7 August 2017

Carolyn McNally  
Secretary  
Department of Planning & Environment  
GPO Box 39, SYDNEY NSW 2001

Further to the meeting with yourself, representatives of the City of Sydney Council (Council) and Mirvac on 30 June 2017, we write to respond to the issues raised at the meeting.

General Arrangement Plans 1:250
 Lower Ground

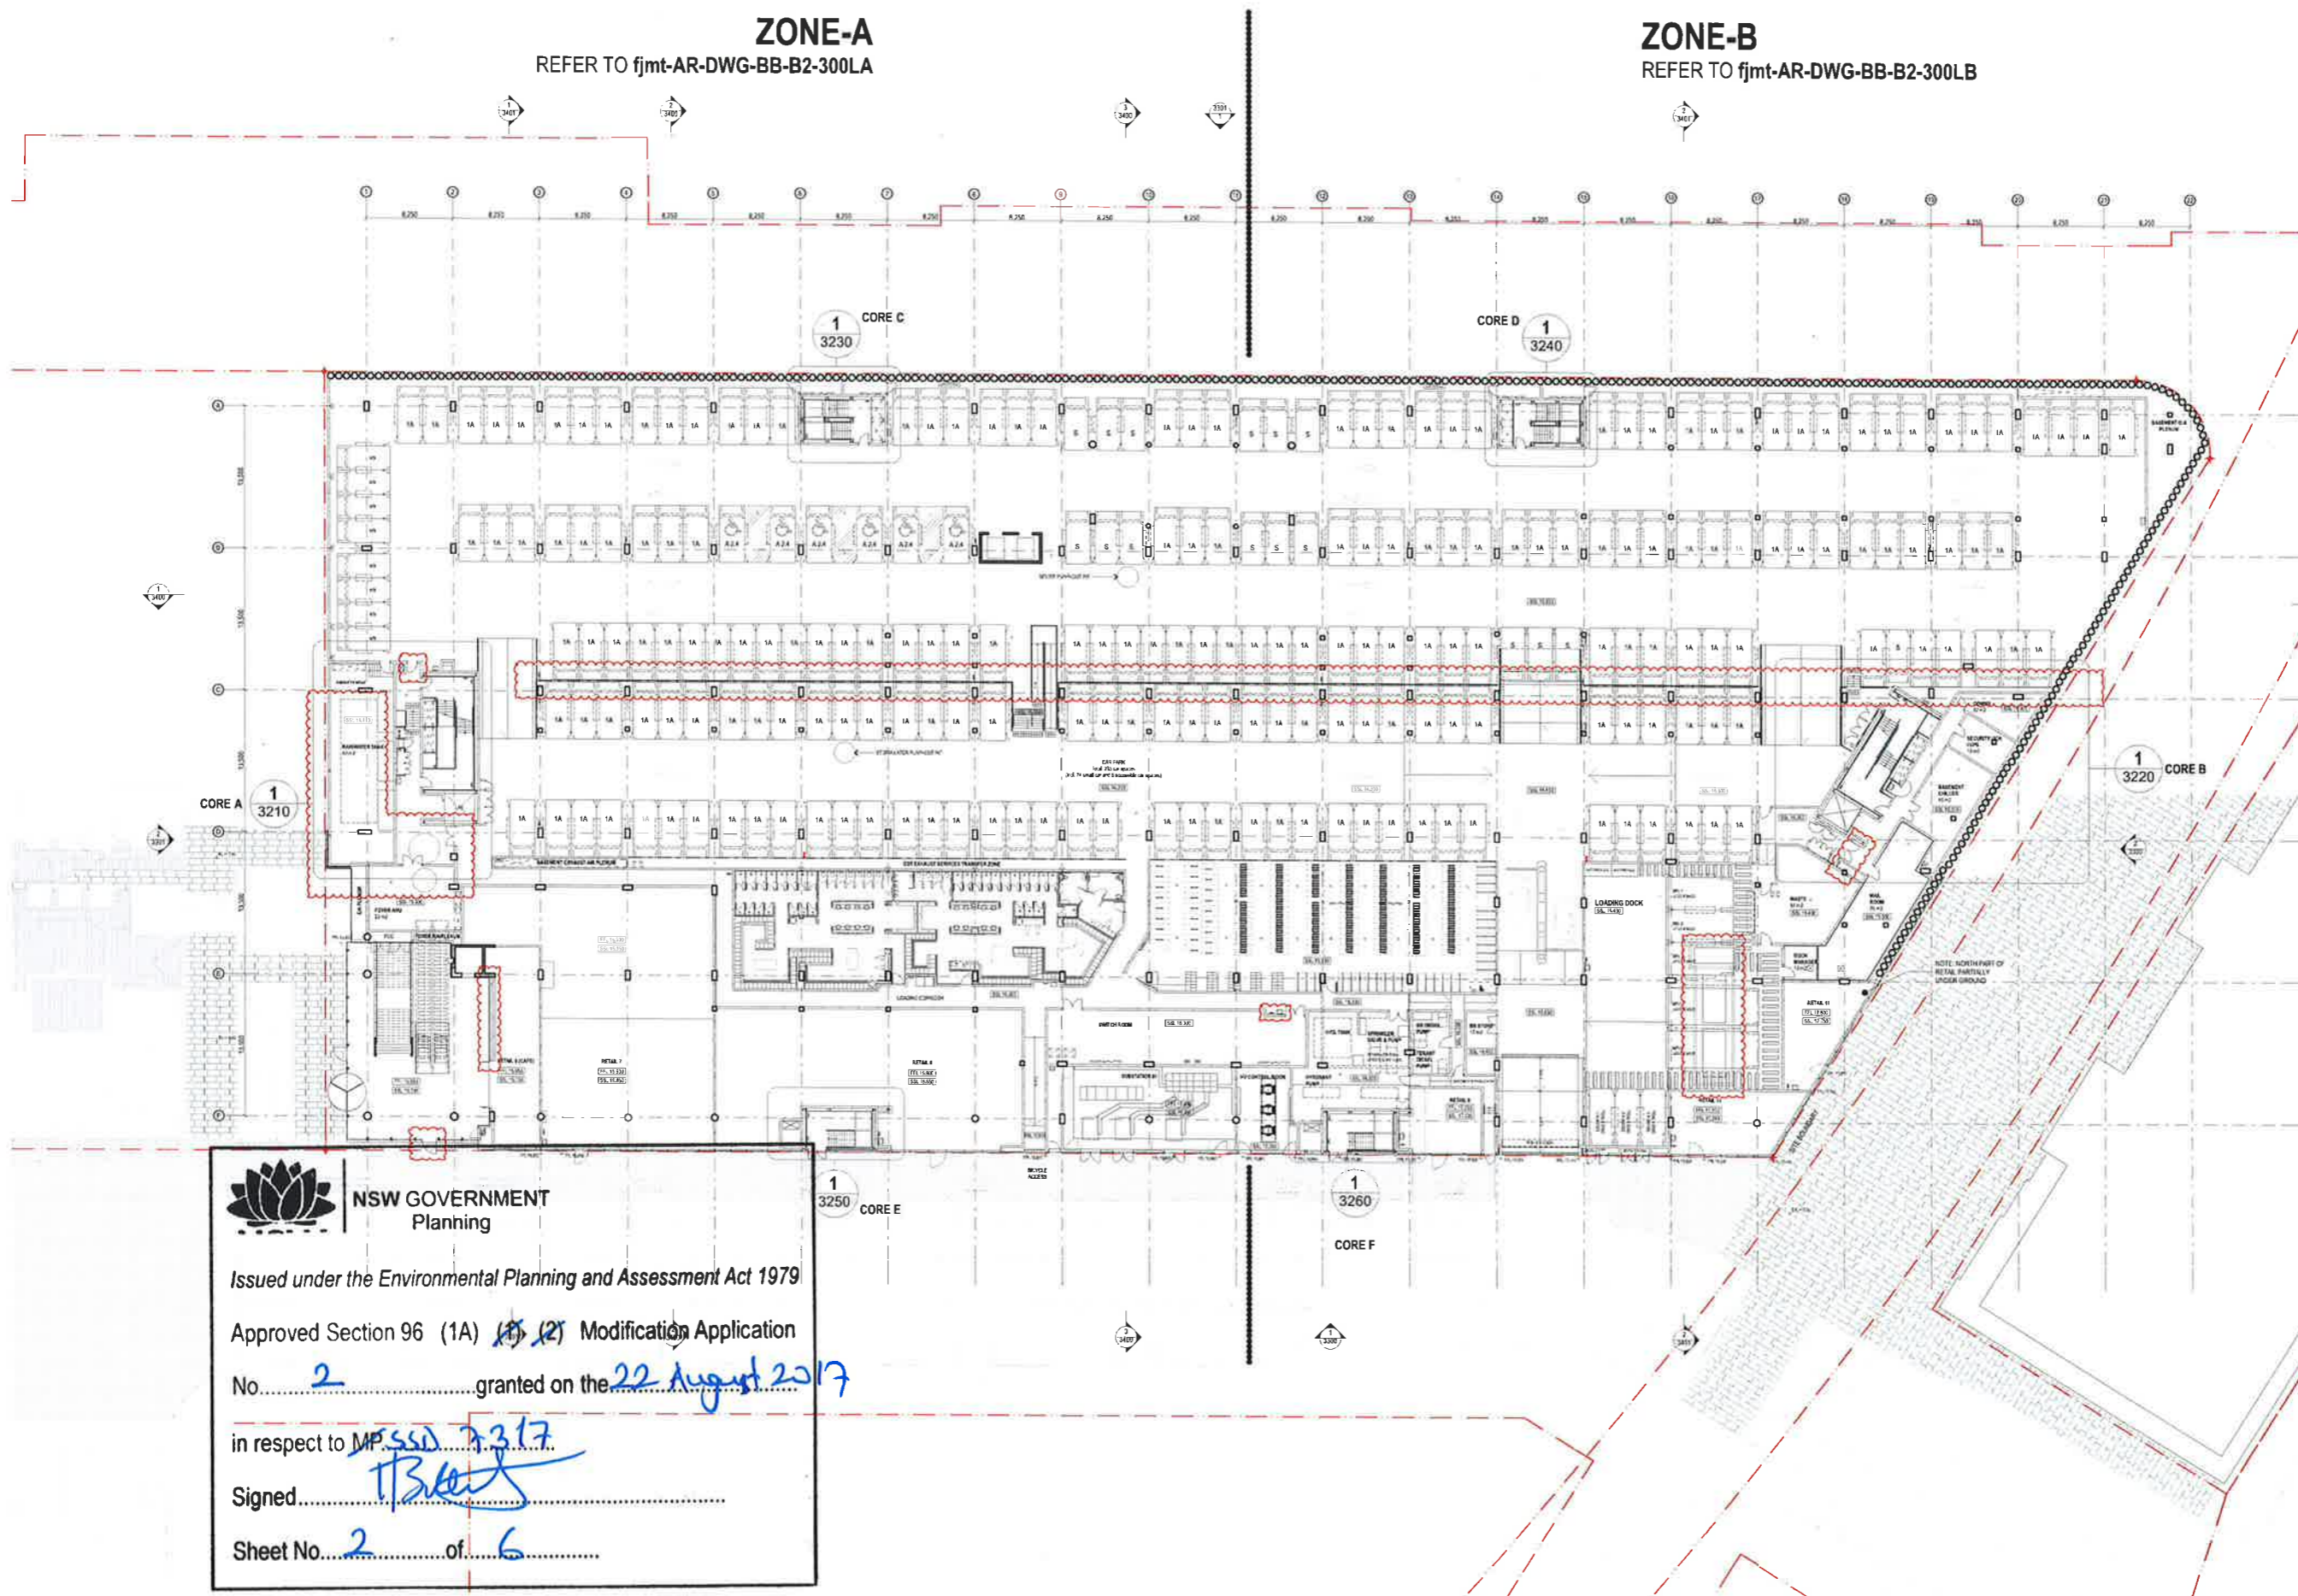
An amended Lower Ground general arrangement plan (Ref: AR-DWG-BB-B2-300L) was included within the package of documents that were submitted as part of the original modification application in April 2017. The plan illustrated a total provision of 234 car parking spaces across the Lower Ground level.

In light of Mirvac's requirement to allocate 500 car spaces within Building 2 and further design development, the general arrangement of the Lower Ground and Mezzanine levels of Building 2 have been further amended. They propose a total of 500 spaces across both levels.

**Table 1** provides a summary of the proposed additional changes to the Lower Ground level and also the newly proposed changes to the Mezzanine level as illustrated on the revised Architectural Drawings, prepared by FJMT (refer to **Attachment B**), along with reasons for the specific changes.

Proposed change	Driver for change
<b>Lower Ground level</b>	
Reconfiguration of parking layout to show a total of 235 spaces at Lower Ground level including 6 accessible parking spaces.	Design development, review and rationalisation of accessible parking requirements and requirement to provide 500 car spaces within Building 2 in total.
Reconfiguration of the rainwater tank room.	Design development – the rainwater tank room is required to accommodate additional grease arrestors.
Alterations to the internal finished floor levels <sup>1</sup>	Design development – required in order to provide design co-ordination and provide adequate clearances for reticulating the building services.
Increase in the size of the generator diesel tanks within the loading dock.	Design development – to accommodate tenant generator requirements.
Provision of additional security doors to the goods lifts and back of house facilities.	Design development – to provide additional security within the car park.

**Australian Technology Park
Indicative Parking Plan**

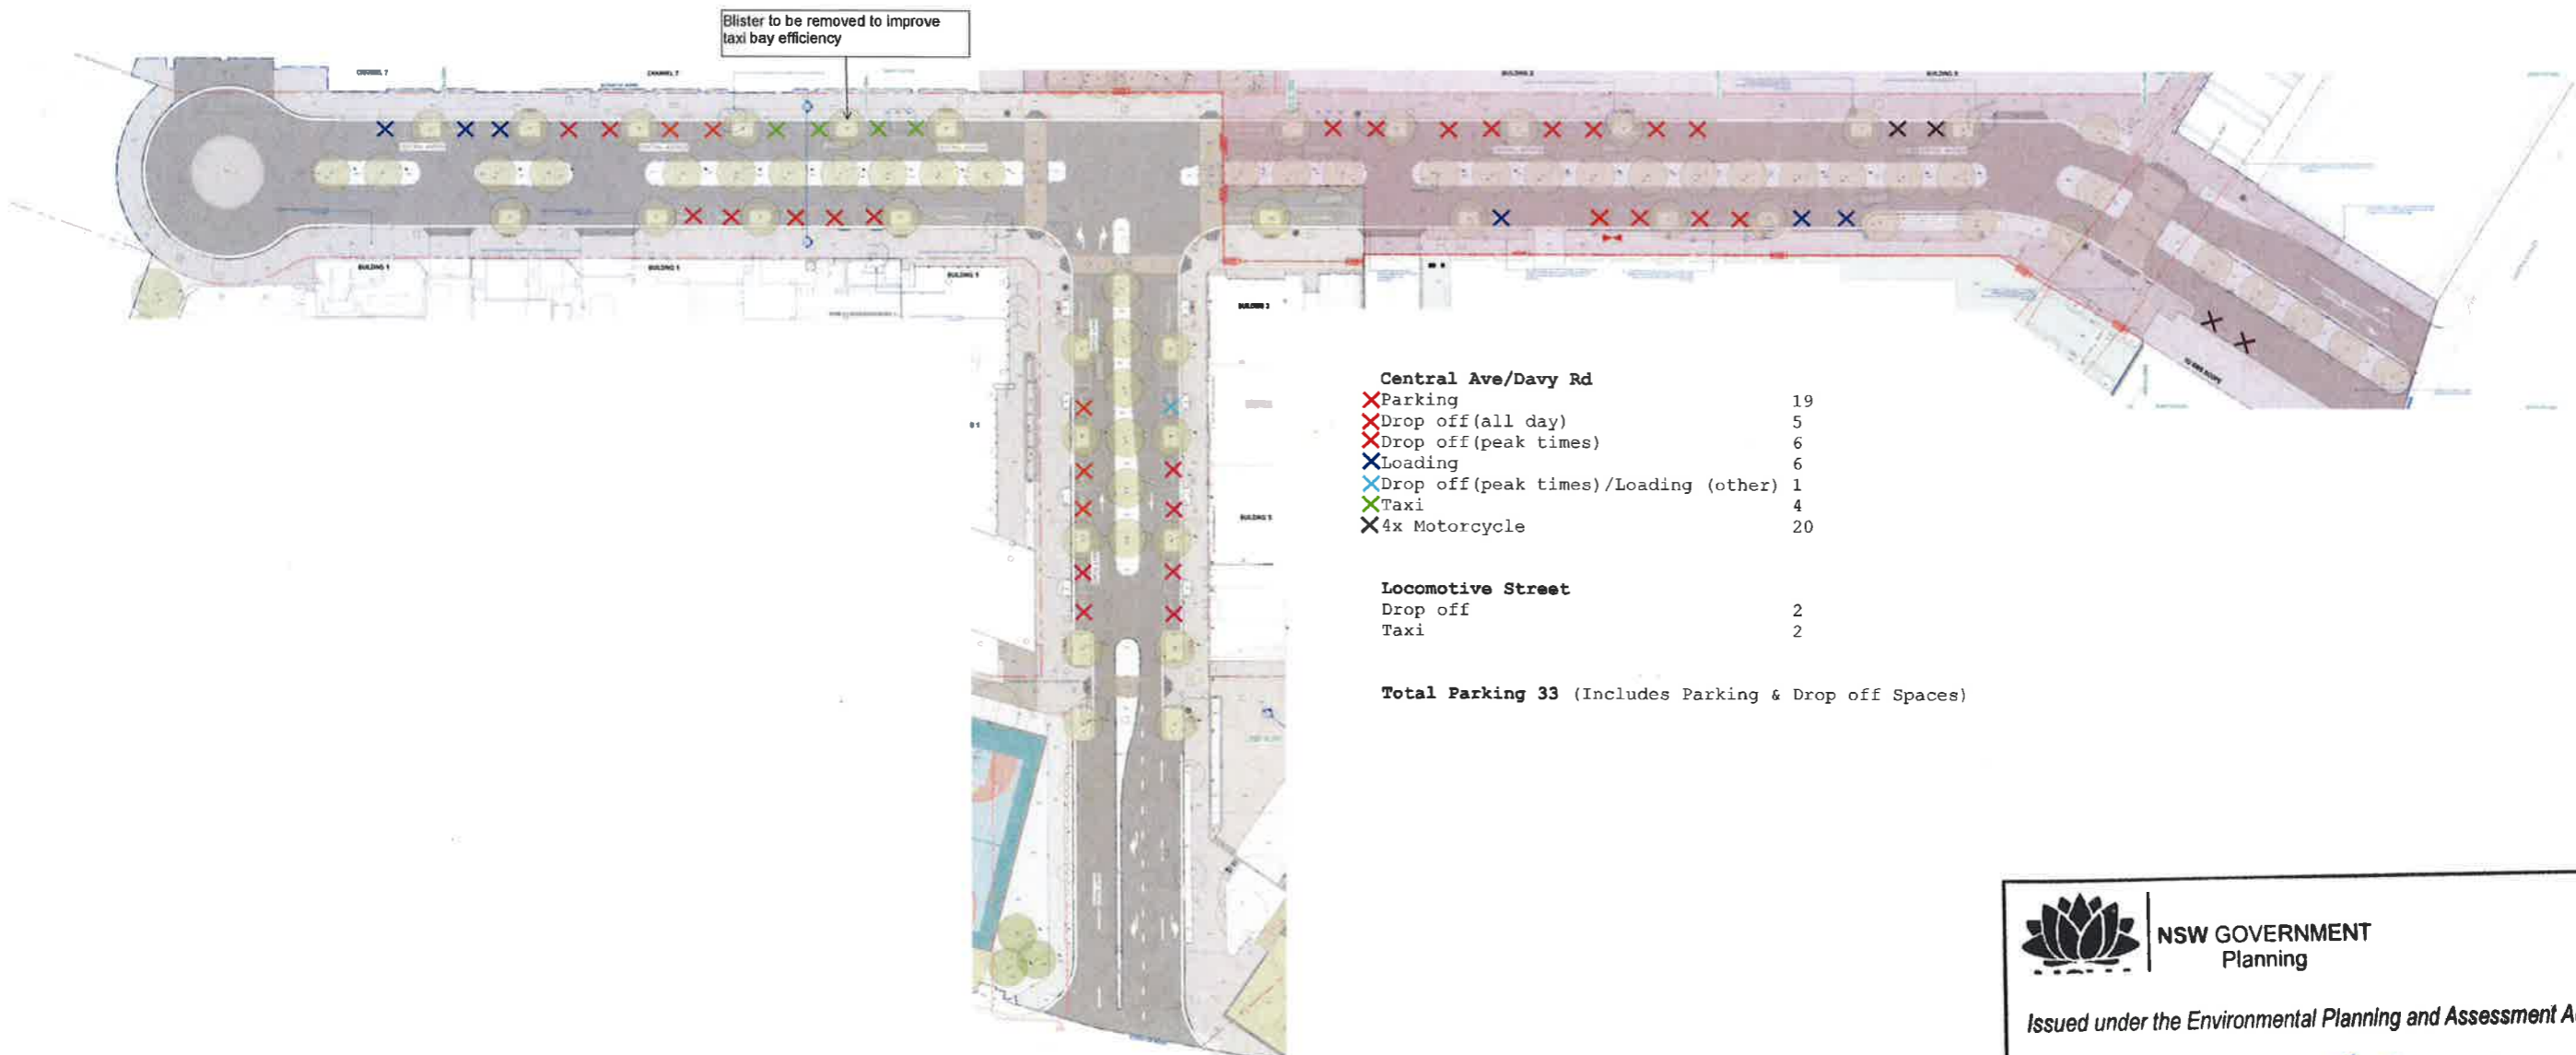
Accordingly, an indicative parking plan for Central Avenue and Davy Road is included at **Attachment C**. It illustrates the indicative provision of 31 on-street car parking spaces (parking + drop-off spaces).

It is proposed that 2 additional drop-off on-street spaces will be provided along Locomotive Street, however the approximate location of these two spaces has not been finalised.

Notwithstanding this, as indicatively shown, it is Mirvac's intention to provide a total of 33 on-street car parking spaces, within the ATP.
